**TfNSW response to EIS - SSD-50587460 – Panorama Battery Energy Storage System - 800 Mid-Western Highway (HW6), Evans Plains**

Transport for NSW (TfNSW) is responding to the EIS exhibition of SSD-50587460 - Panorama Battery Energy Storage System (BESS) referred on 19 July 2024.

TfNSW has reviewed the information submitted in the Environmental Impact Statement (EIS) and Traffic Impact Assessment (TIA) prepared by SLR Consulting. TfNSW requires additional information to assess the impacts on the State road network associated with this project. Details of **additional required information** are set out in **Attachment 1**.

Plan Title:	PANORAMA BESS 100MW/200MWh	Drawing No:	CIV101
		Sheet No:	1
		Revision:	H

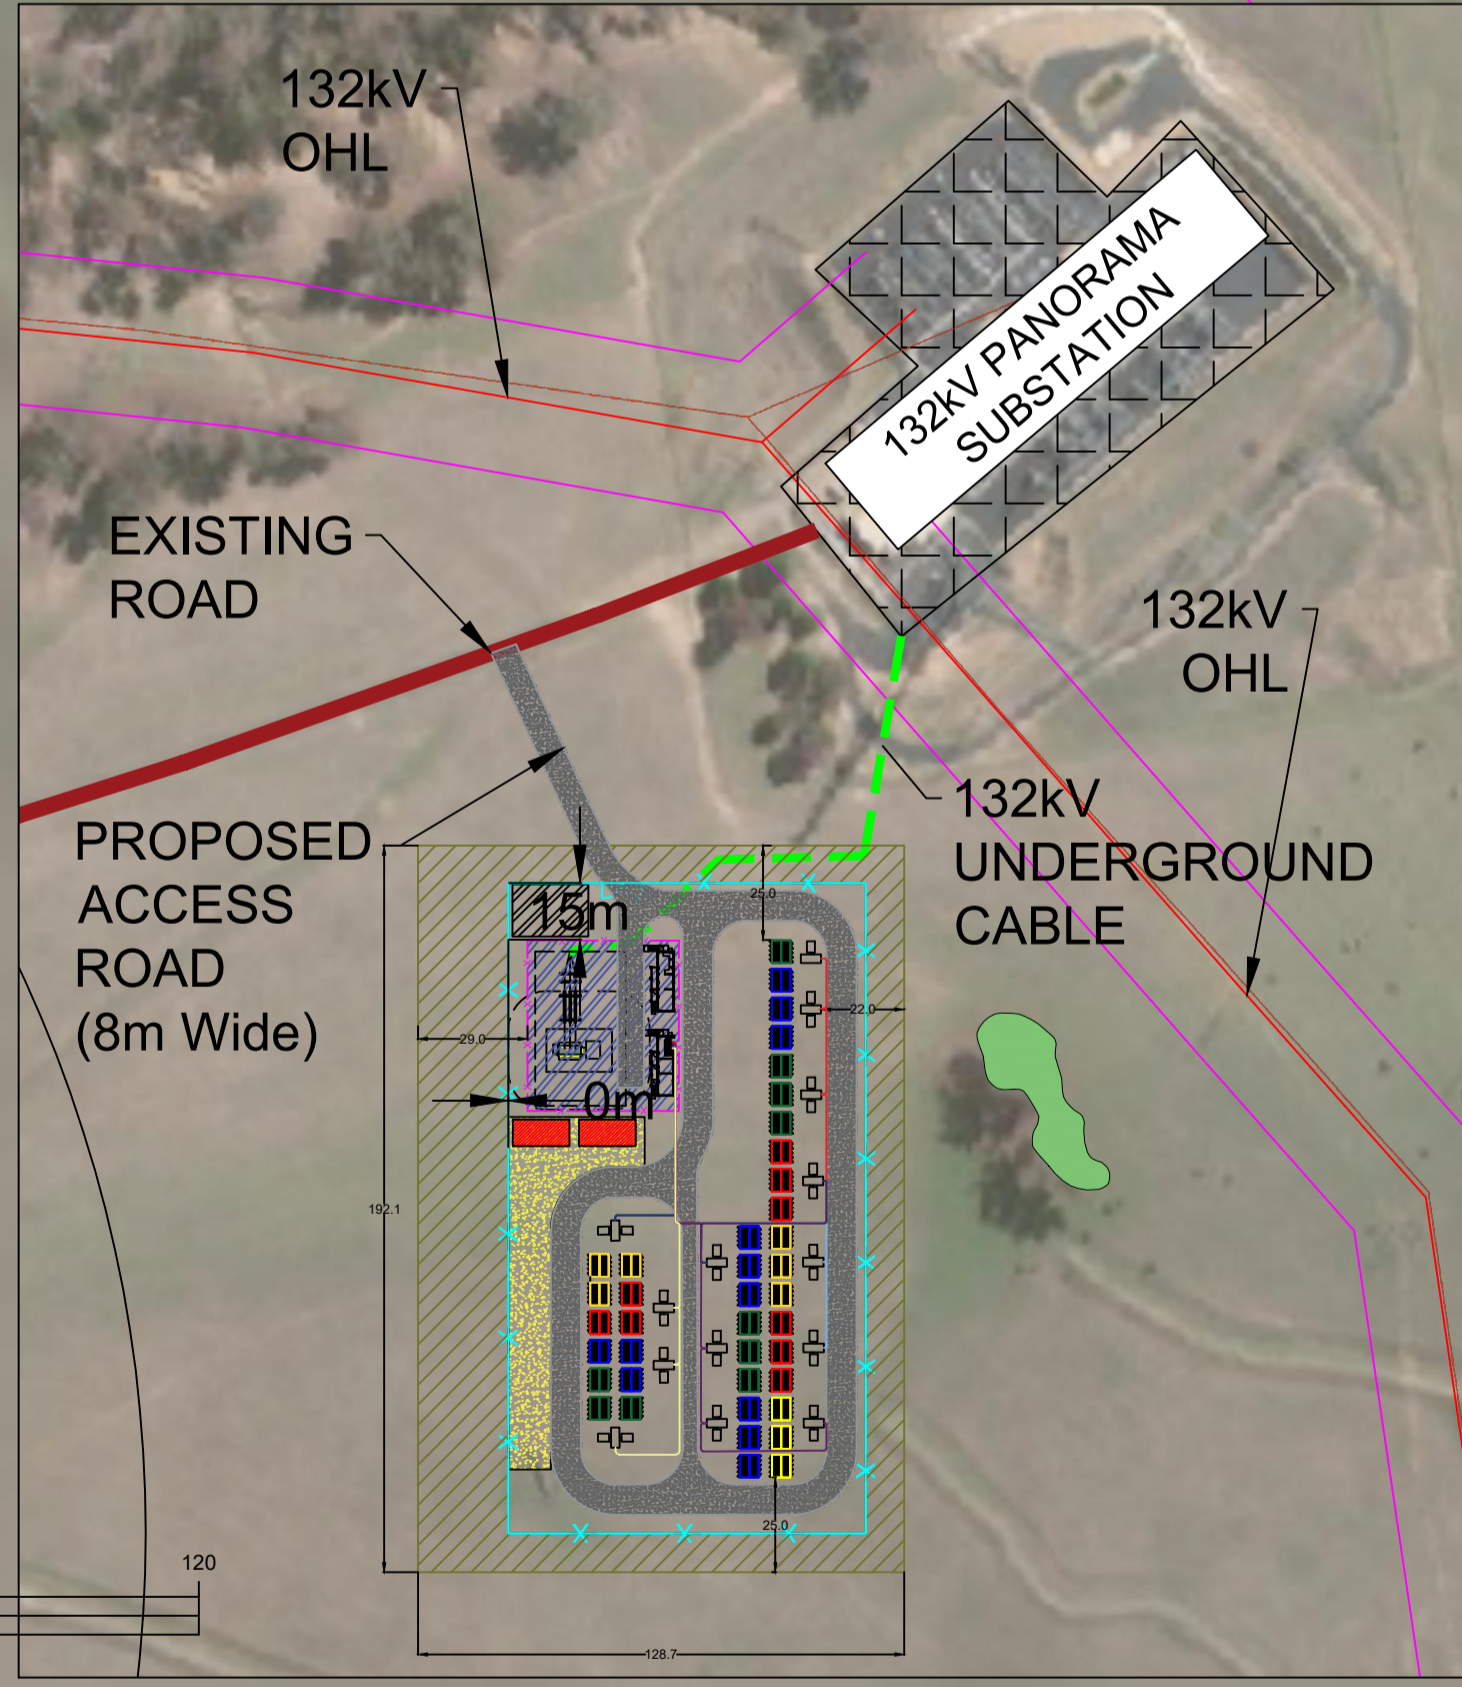
1. The Safe Sight Intersection Distance (SSID) assessment for the proposed site access within the TIA identifies the sight distance achieved is 270 metres to the west, 30 metres short of the required 300 metres (100km+10km/hr for a 2.5 sec reaction time). The SSID assessment is to be revised to identify measures to achieve compliant SSID for the design speed.

12. There are concerns over current location of the site access due to the following constraints:
  - The curve in the road restricts SISD compliance, particularly towards the west.

- The site access is located at the bottom of a vertical grade, where speed is likely to be higher, potentially causing issues for heavy vehicles trying to slow down to access the site.

- The short distance between the site access and an existing bridge west of the site (approximately 40m).

If the above issues cannot be addressed an alternative location to the site will be required.
